RFI

RFI #: 77
Date: 3/15/2012
Job: EB-02 Keller Springs Lofts
Phone: 877-777-5115

Subject: Conflicts with meter center locations and numbers

RFI #: 96
Date: 3/28/2012
Job: EB-02 Keller Springs Lofts
Phone: 877-777-5115

SHEET NUMBER
3.1C
BLDG PLAN 'C'

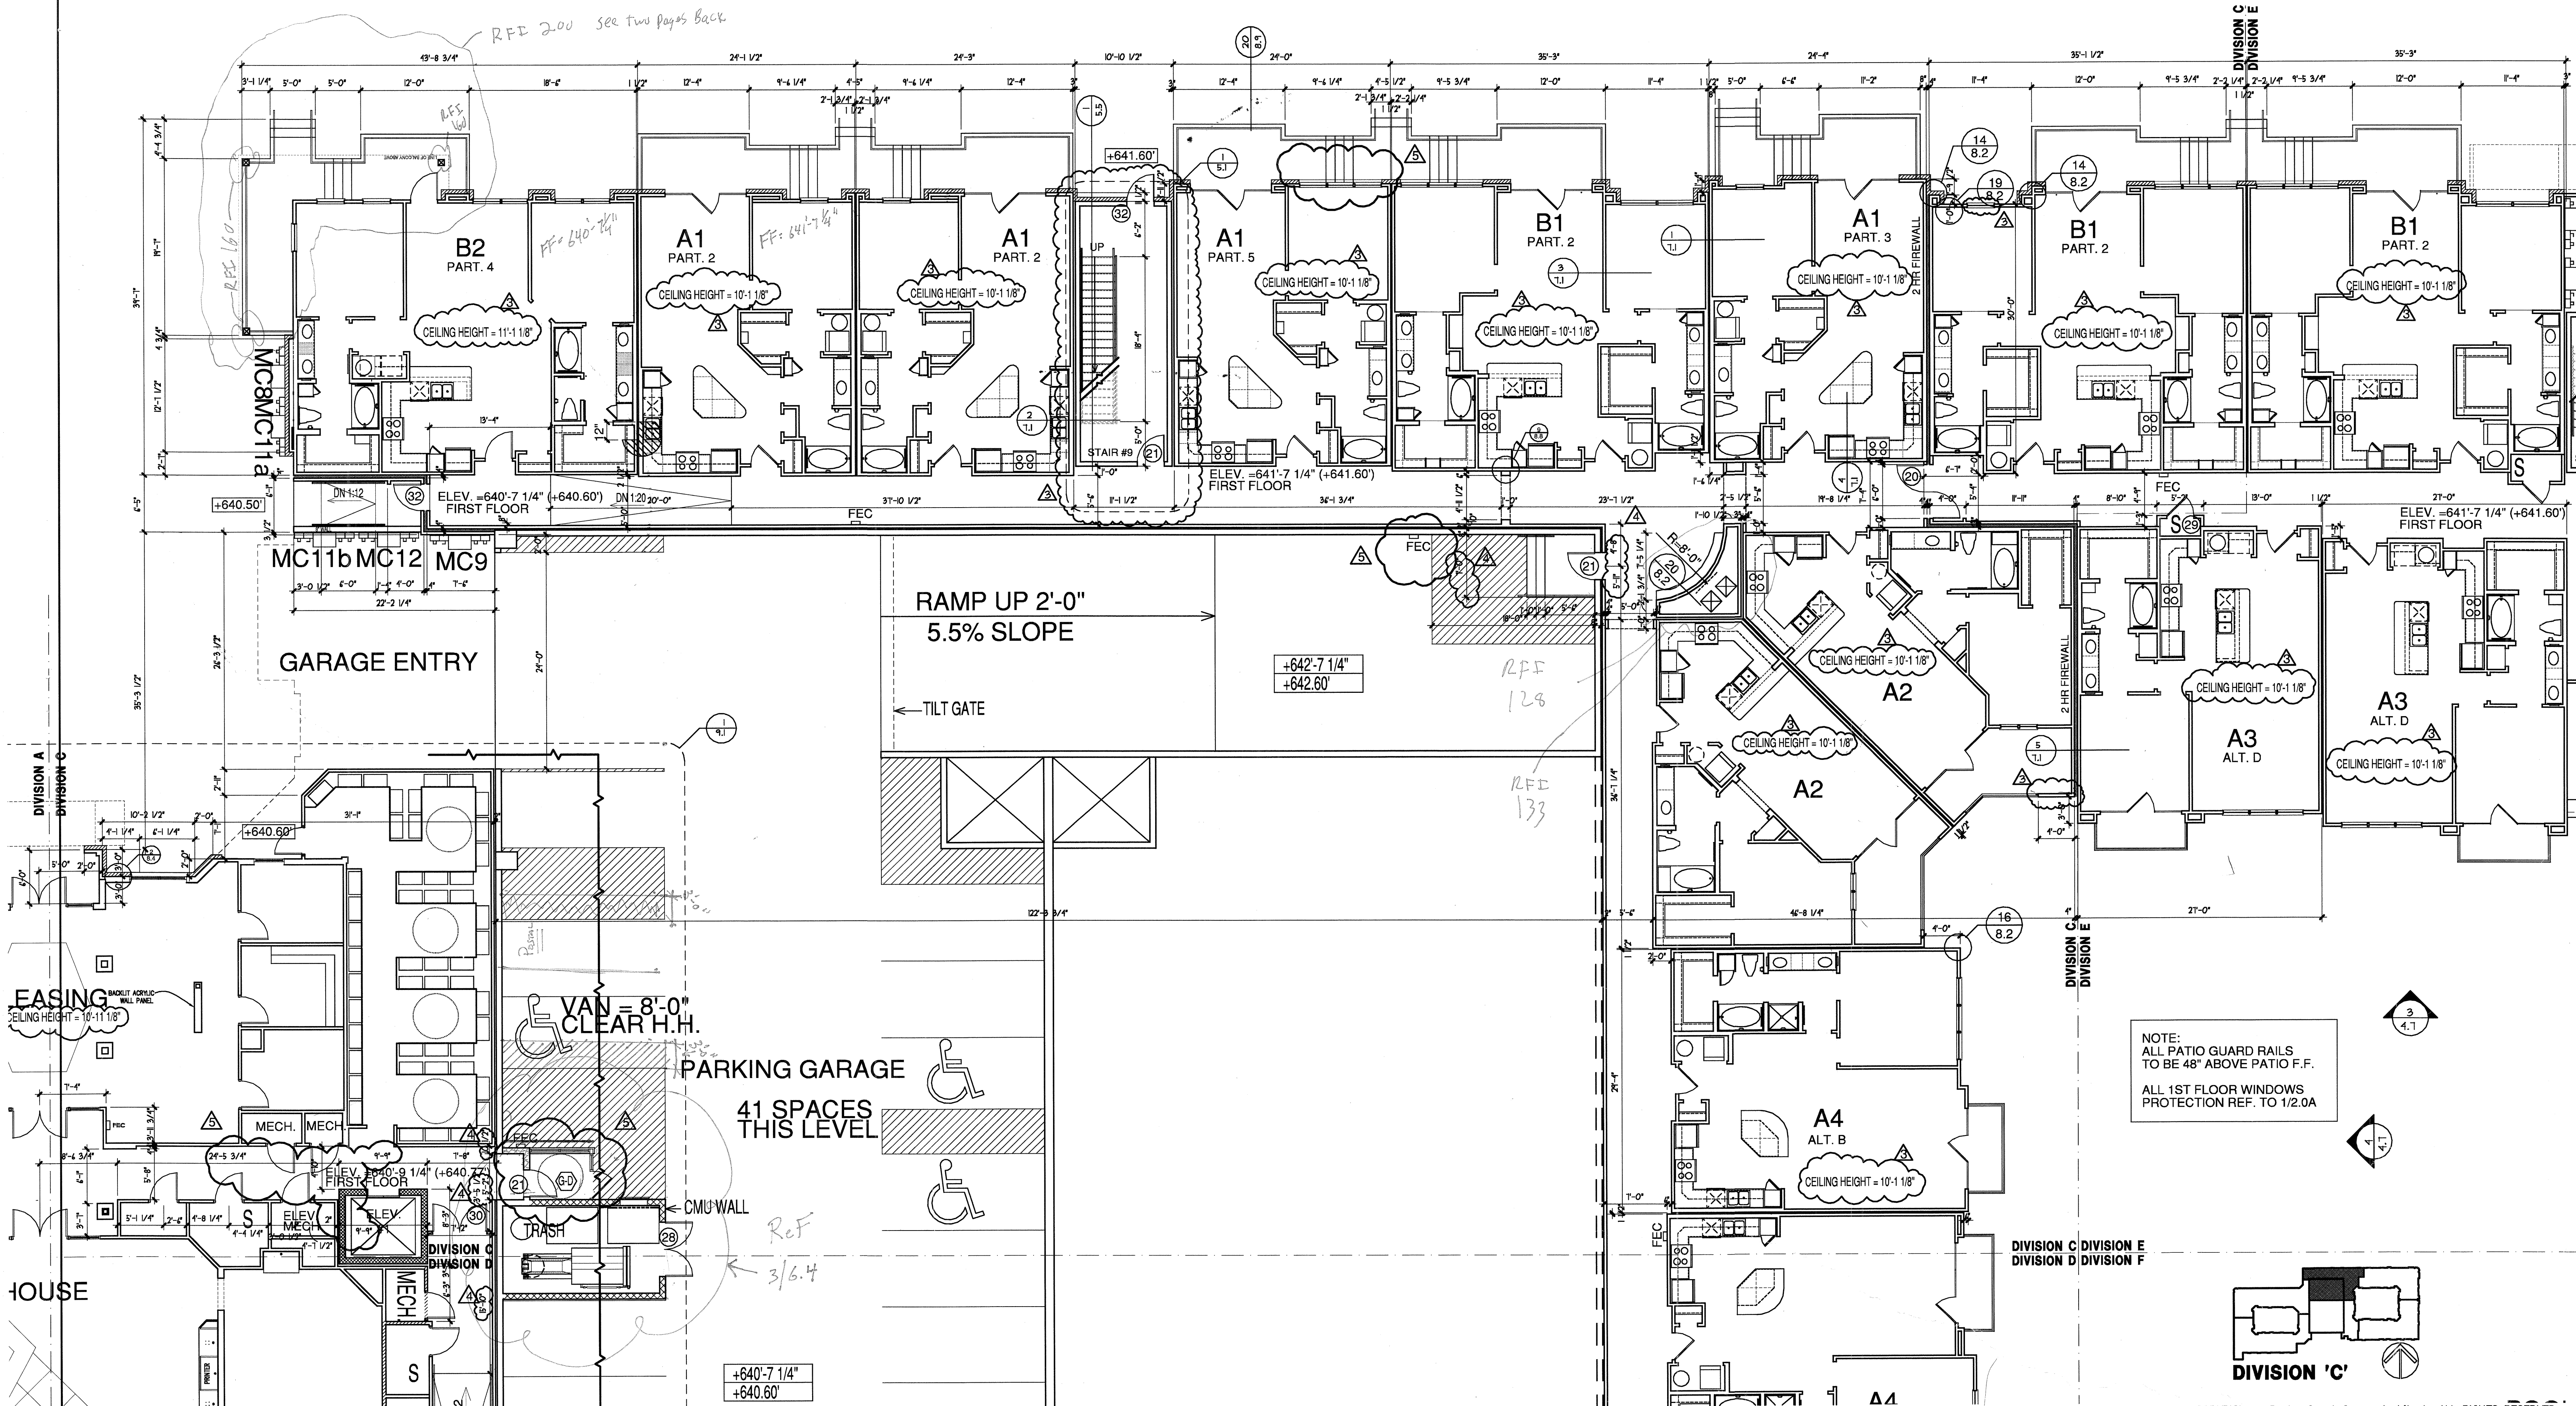
Some of the meter centers have changed location and numbers. 3.1C in Architectural and E-3.1C have different meter center numbers than the final E-10.1 and encore Final drawing. Also, E-10.1 and Oncor show two meter centers inside the garage. This must be a mistake. The meter centers should be mounted to the exterior of the building as shown on 3.1C and E-3.1C. I think we may want to have the meter center numbers match the Oncor plans and change from 3.1C and E-3.1C. These conflicts are very confusing and need to be corrected so we get them in the right place. Please see attachments and advise.

The meter centers were updated as part of rfi 96 on March 30th. The meter center names shall match those shown in the rfi 96 response. See attached for rfi response and updated drawings.
